RE: DARLING SQUARE NORTH PLOT – MEMORANDUM ON PROPOSED DESIGNS FOR PERFORATIONS WITHIN THE RISER FACES AT THE EXTERNAL STAIRWAY v3

The following statement pertains to the external stairway that runs from ground level to level 1 at the North Plot building at Darling Square in Haymarket NSW.

Eden Fong
Morris-Goding Accessibility Consulting

Figure 3.5.1_The external stair has been redesigned to extend to the first level of the library.

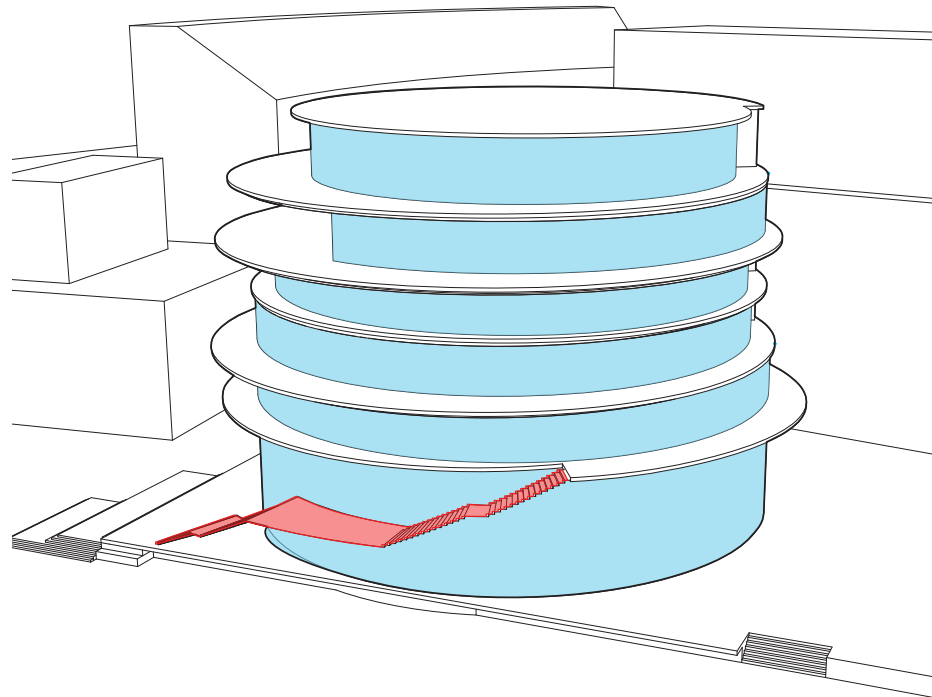
AS1428.1(2009) requires stairway risers to be opaque. This is because, when ascending a stairway, a given user would need to identify the location of the few next treads ahead of them so that they can judge where to next place their feet. If that user's vision was either low or impaired, it would be especially critical for that user to have the ability to detect the locations of the next few treads.

Stair risers that are fully transparent would allow a particular user on a stairway to see through the treads to the areas below, and beyond, that stairway. This would have a tendency to introduce visual ambiguity for users with low or impaired vision as to the location of the next few treads.

For the external stairway at the North Plot building, three options have been tested for the provision of perforations at the faces of the stair risers. Based on the supplied design studies, all three options would be reasonable solutions to allow a user with a vision impairment to identify the next few treads of the stairway when he or she is ascending the stairway. This is because, from the point of view of such a user, the visual transparency through the next few riser faces would be kept to a minimum due to the size of the pattern when viewed from above. This is illustrated in Figure 1 below.

MGAC have reviewed the visual studies provided of each option, and confirm that there would be no direct line of sight through the perforations for a user when he or she is physically on the stairway itself. This would have the effect of minimising the ambiguity for such users as to the location of the next treads, and would be supportable as a Performance Solution.
